Arun District Council  
Arun Civic Centre  
Maltravers Road  
Littlehampton  
West Sussex BN17 5LF  
Planning & Building Control General Enquiries  
Tel: (01903) 737756 Fax: (01903) 730442  
Dx: 57406 Littlehampton  
Minicom: 01903 732765  
e-mail: [planning@arun.gov.uk](mailto:planning@arun.gov.uk)  
website: [www.arun.gov.uk/planning](http://www.arun.gov.uk/planning)

Application No: LU/93/20/HH  
Site Address: 45 Tideway Littlehampton BN17 6PP  
Description of works: Front mono pitch extension enlarging entrance hallway and creating a utility area.

Thank you for your internet representation made on 29th May 2020 which has been recorded as an objection with the comments as follows:

East Elevation(Front) at 1:100 Scale

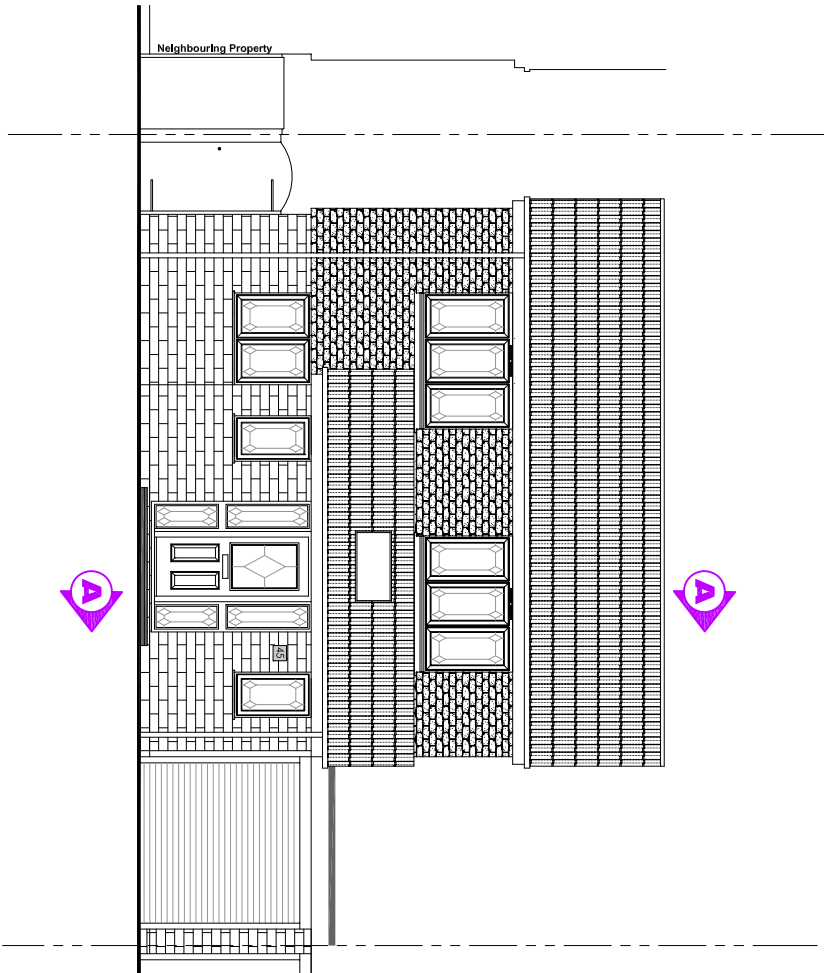
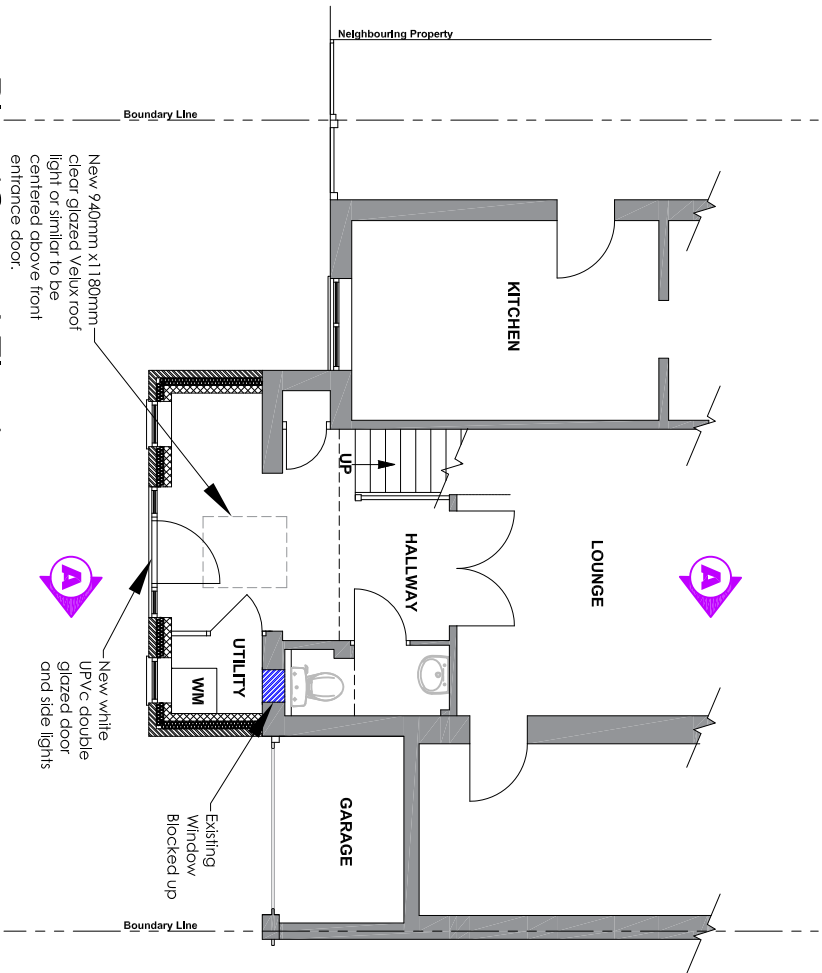
The Town Council's Planning and Transportation Committee considered this matter at its meeting held on Tuesday 26th May 2020 and objected to the application. Observing that the proposed development would extend the front of the property beyond the building line, the Committee objected to the application on the grounds that it was overbearing and out of character in terms of its appearance compared with existing development in the vicinity.
